From: Zac Denton
Sent: 07 December 2018 14:59
To: Karen Parsons
Subject: FW: LU/261/18/PL - Request for additional information

North Elevation (To River Road).

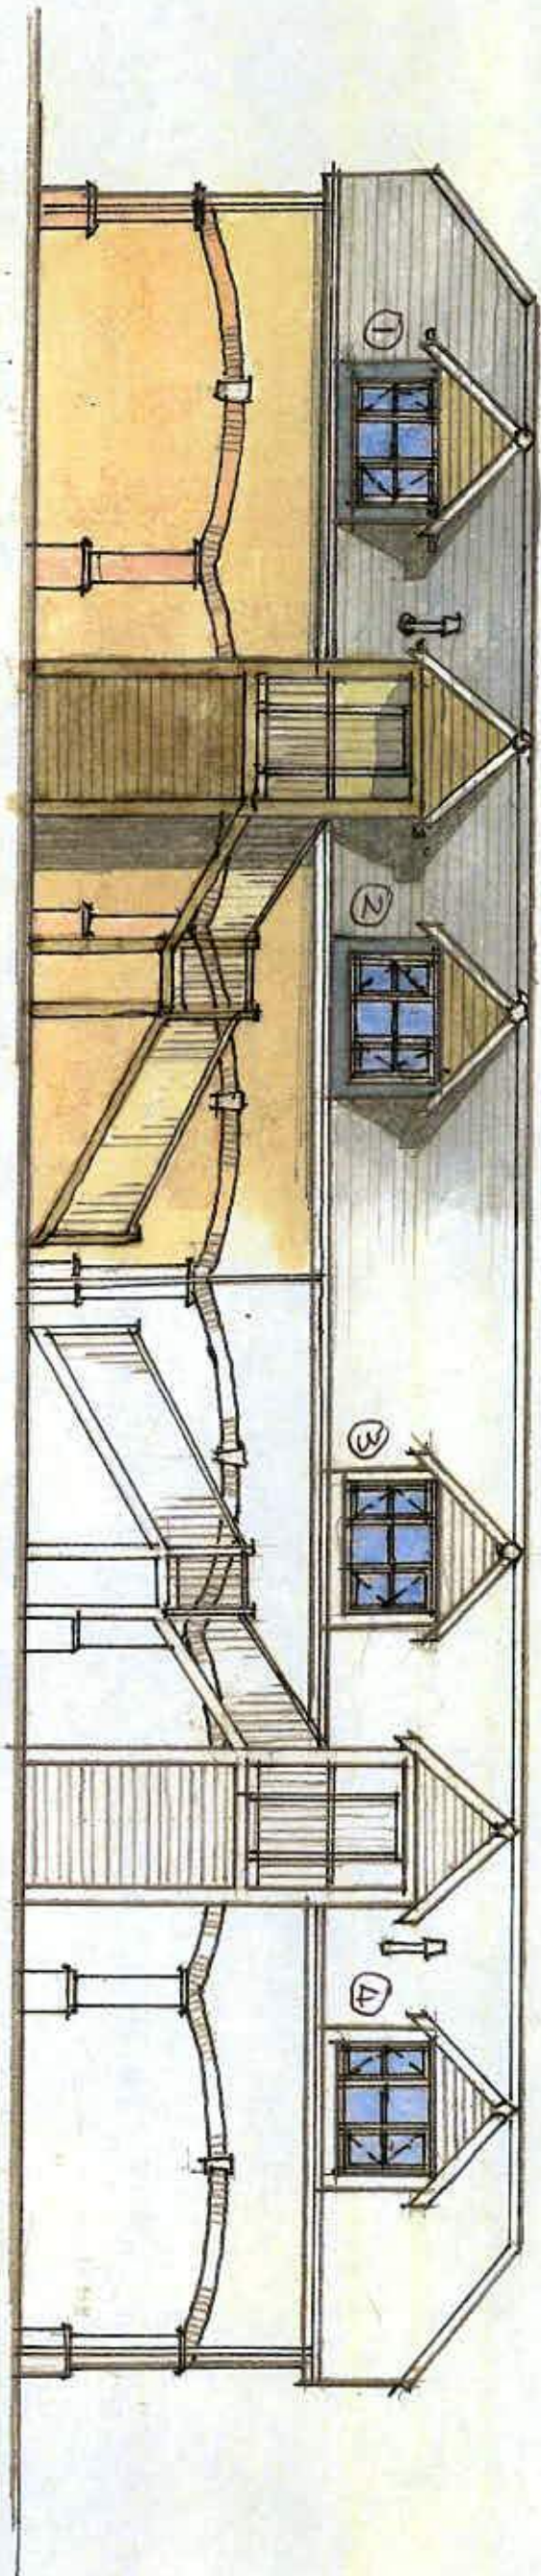
Following a discussion with The Council's Conservation Officer, I was wondering if you could submit further details of the window design? This should include layout of glazing bars, how thick these bars will be, how thick the frames will be etc.
